784-A117904 (014)

23rd July 2021

Response to comments received from Anderson Acoustics (AA) received on 8th July 2021 regarding the submitted Noise Assessment by Tetra Tech [ref 784-A117904 (014) dated 19th May 2021] for planning application reference 39439/APP/2021/2230.

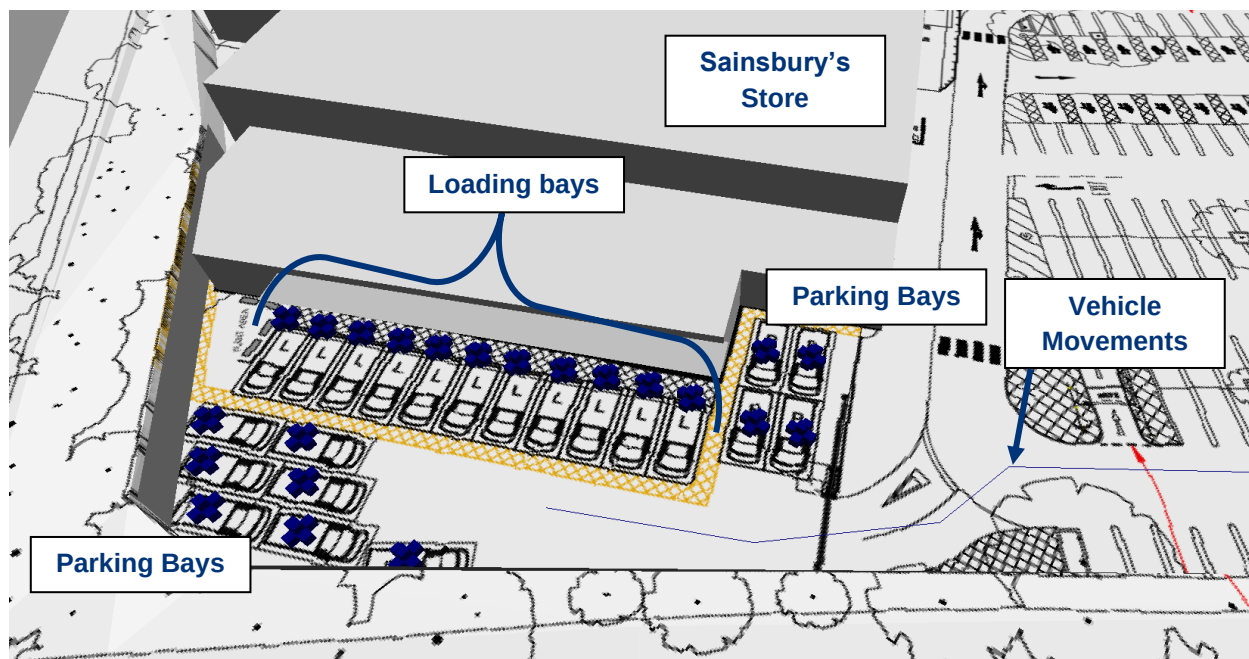
The Assessment Methodology is updated to clarify the provenance and selection of source values and how they have been used in the model. It is considered that further thought is given to the approach to the early morning scenario: how “100% unloading capacity” has been interpreted and modelled.

The source input data used for the assessment is taken from measured levels of an operational GOL facility the Sainsbury's store at Pontypridd. The assessment undertaken for this store was actually for a jet wash facility (planning application 12/0207/10) where the WYG-branded report is available online. However, whilst undertaking the baseline noise survey, source measurements of the operating GOL facility were undertaken to inform future modelling of proposed Sainsbury's GOL facilities and are considered to represent robust source noise levels associated with activities within GOL service yards, with the assessment assuming all parking bays and unloading bays are operating simultaneously.

With regards to the morning scenario, the assessment assumes that all 11 unloading bays would be in use at the same time during this early morning period. This has been modelled using point sources, with Figure 1 below detailing the location of these as well (as the parking bays and vehicle movements); for completeness, the overlain architect's plans are also shown.

Figure 5 Daytime Background L_{A90} Levels for LT1 (used for R01 and R02)

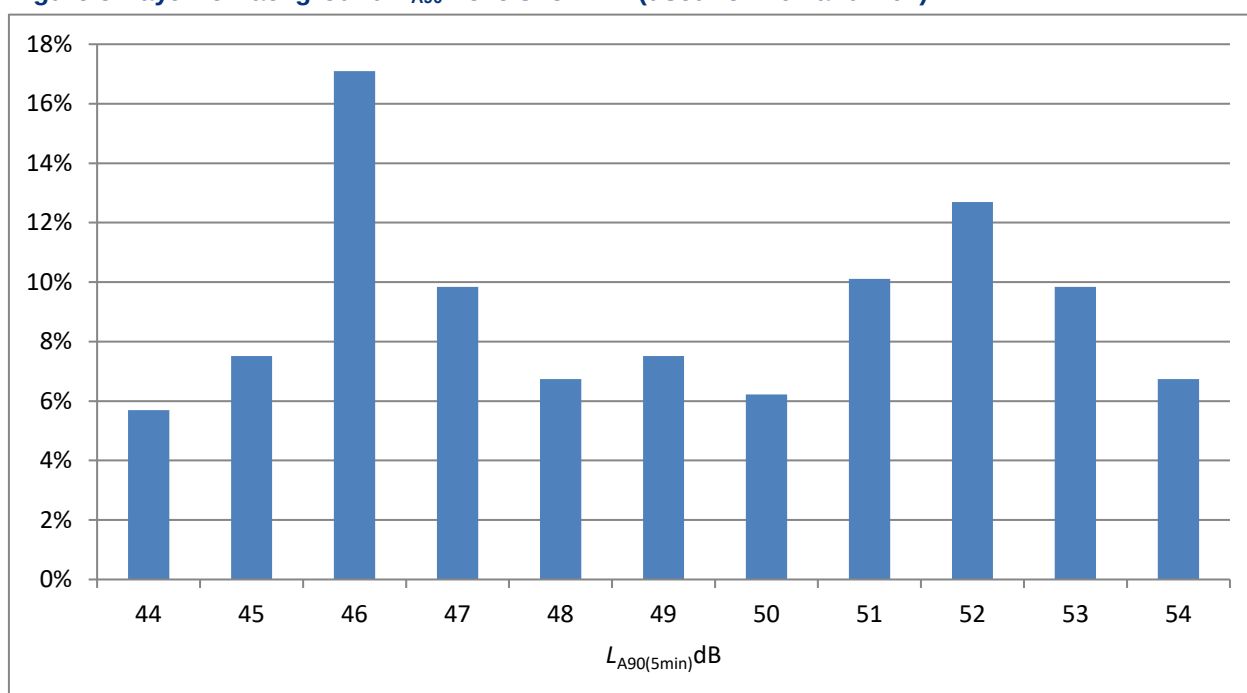
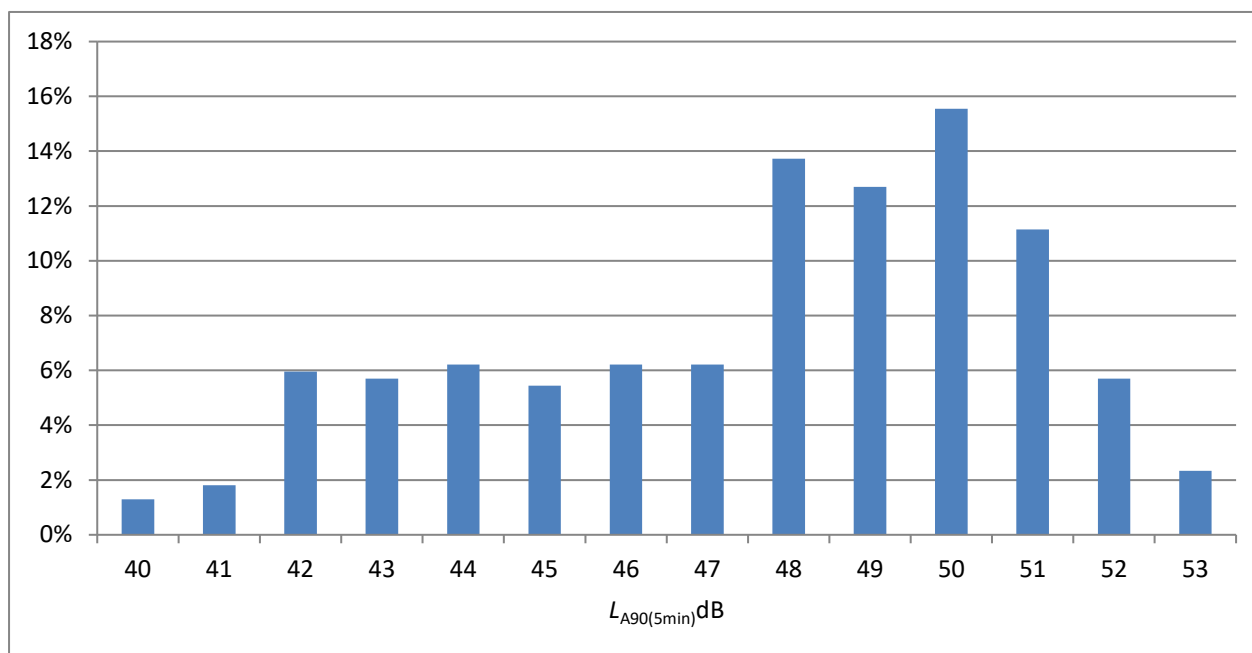
The Noise Survey section is updated to provide further details of the survey (including photographs) and the data, with discussion provided to show full understanding of the results and justification for the selection of the adopted background and ambient levels. Reference should be made to the advice in BS 4142 as to the selection of representative background levels.

To determine the background levels, the monitoring locations were chosen as they were located a similar distance from the principal noise sources as the receptor locations; due to the longer exposure time of the unattended monitoring, the results of the long-term monitoring locations was given greater weight within the assessment. Figures 5-6 graphically show the distribution of measured background daytime L_{A90} levels at LT1 and LT2, which have been used for nearly all assessed receptor locations, with the exception of R10, where ST4 was chosen as no long-term unattended monitoring could be safely undertaken at that location.

Figure 5 Daytime Background L_{A90} Levels for LT1 (used for R01 and R02)

Figure 5 Daytime Background L_{A90} Levels for LT2 (used for R03, R04, R05, R06, R07 and R08)

As shown above, statistical analysis of daytime background levels shows that a noise level of 46 dB for LT1 and 50 dB for LT2 are representative of background noise levels during the daytime period, in-line with the guidance presented in BS 4142. To determine the evening (19:00-23:00) and early morning (06:00-07:00) periods, an hourly breakdown of L_{A90} levels was undertaken for LT1 and LT2 and the average for these time periods were taken to determine the background L_{A90} for these periods.
